130 Saddle Ridge Loop
Cle Elum, WA 98922
August 3, 2018

My husband, Mike and I are owners within the Tumble Creek community of Suncadia and own a cabin at 130 Saddle Ridge Loop. We are concerned about the proposed development of Suncadia Phase 3 Division 14 LP 18-0002, which is an extension of Tired Creek Lane.

Site Development Plan Phase 3 Division 14 Tumble Creek July 18, 2018

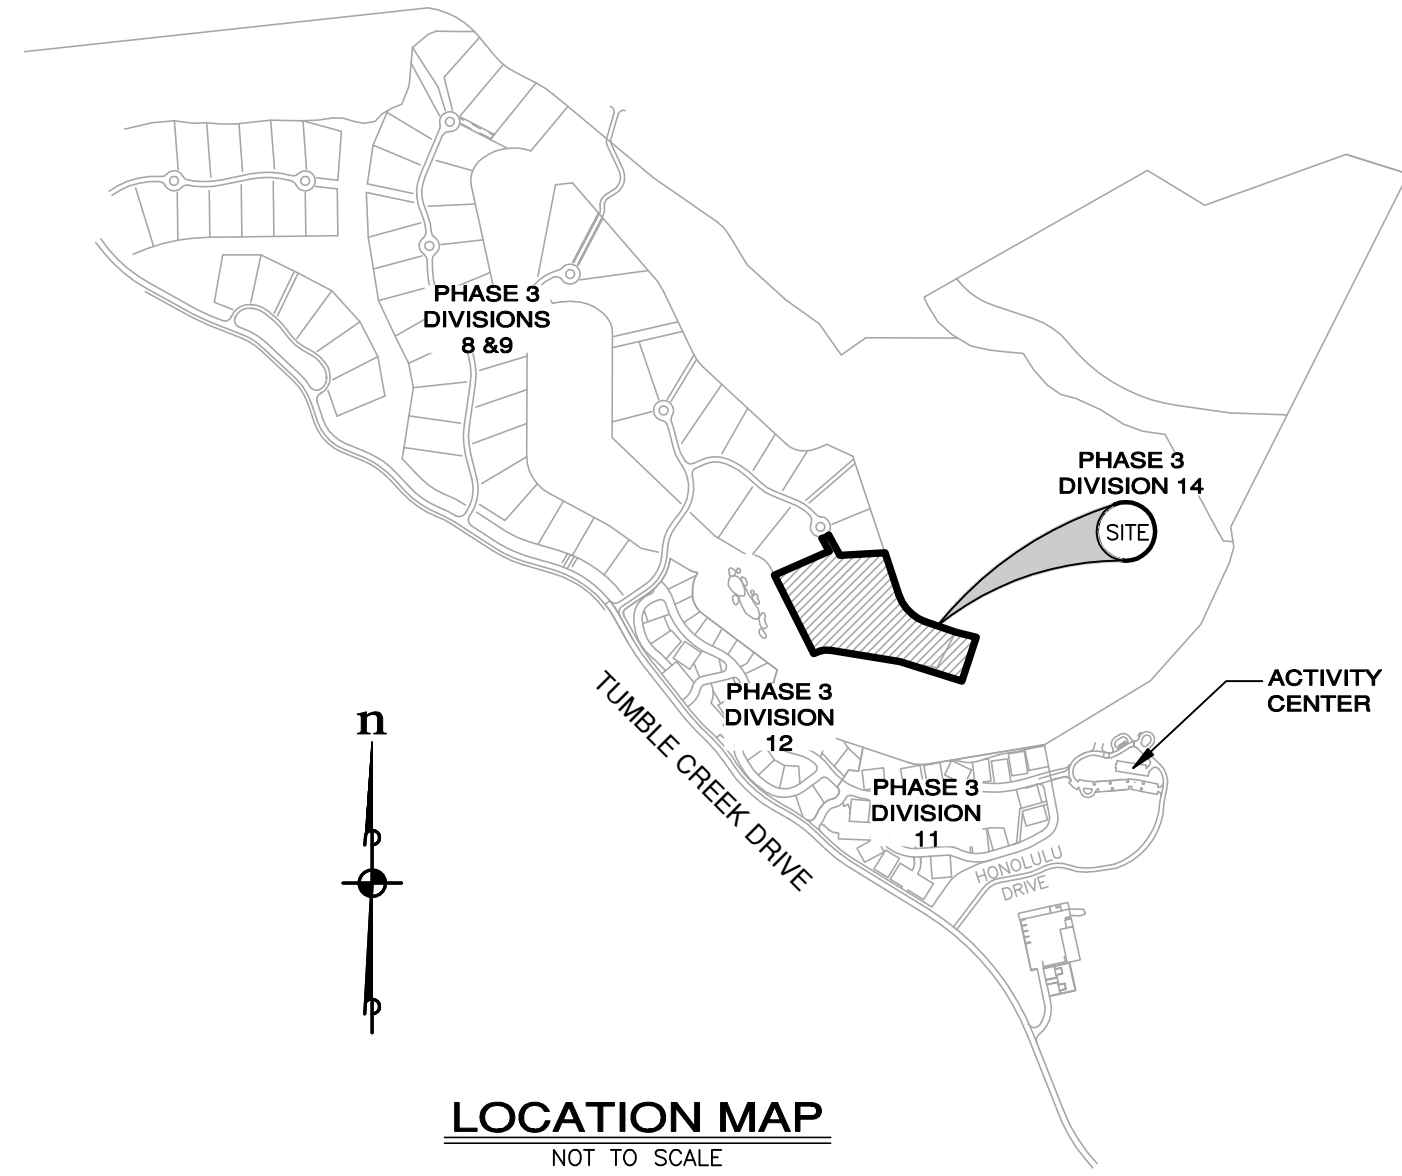
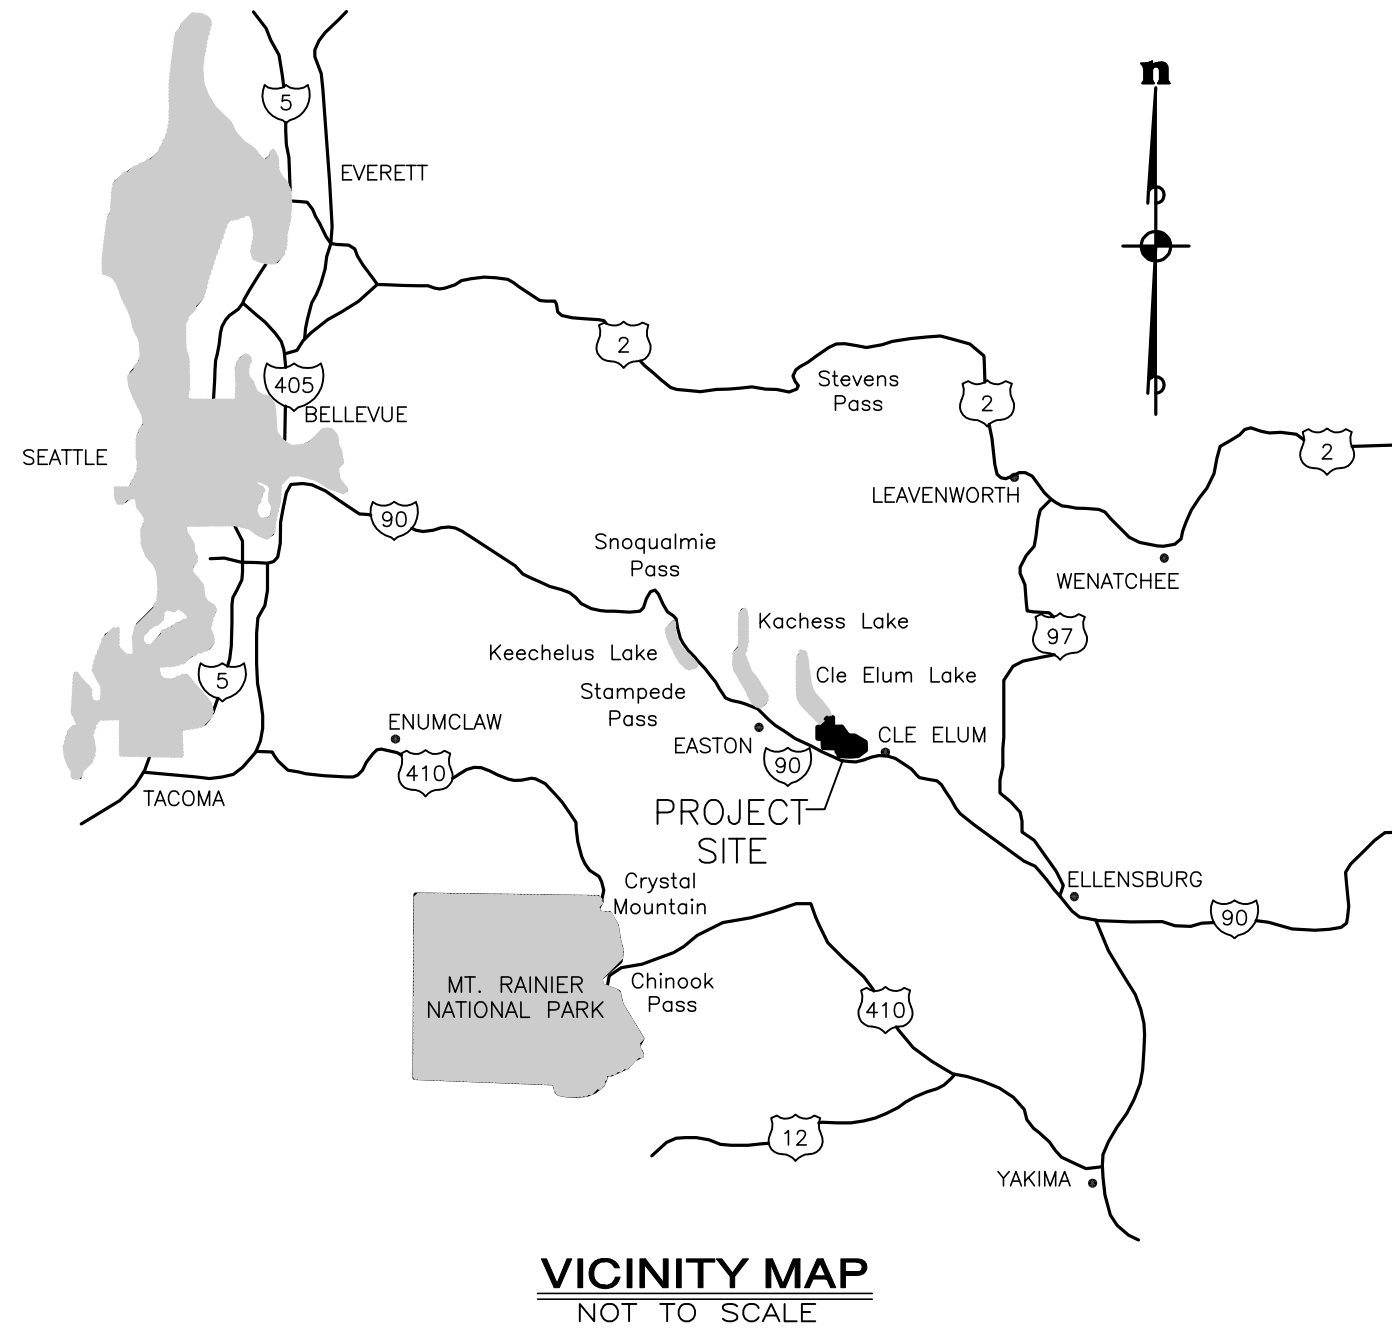
Our concerns are building heights which exceed the standards currently established and enforced by the Design review committee, building locations within the designated sites, the loss of vegetation and potential impact to the stability of the hill on which the development will be built and the impact on wildlife.

We respectfully request that Kittitas County require the Developer to adequately study the environmental impacts, impose maximum height restrictions of 34' as measured from the more restrictive of finished or existing grade to the highest ridge above, inclusive of chimney stacks on the roof, provide plans for parking and staging and require that all buildings strictly comply with Tumble Creek Design Guidelines.
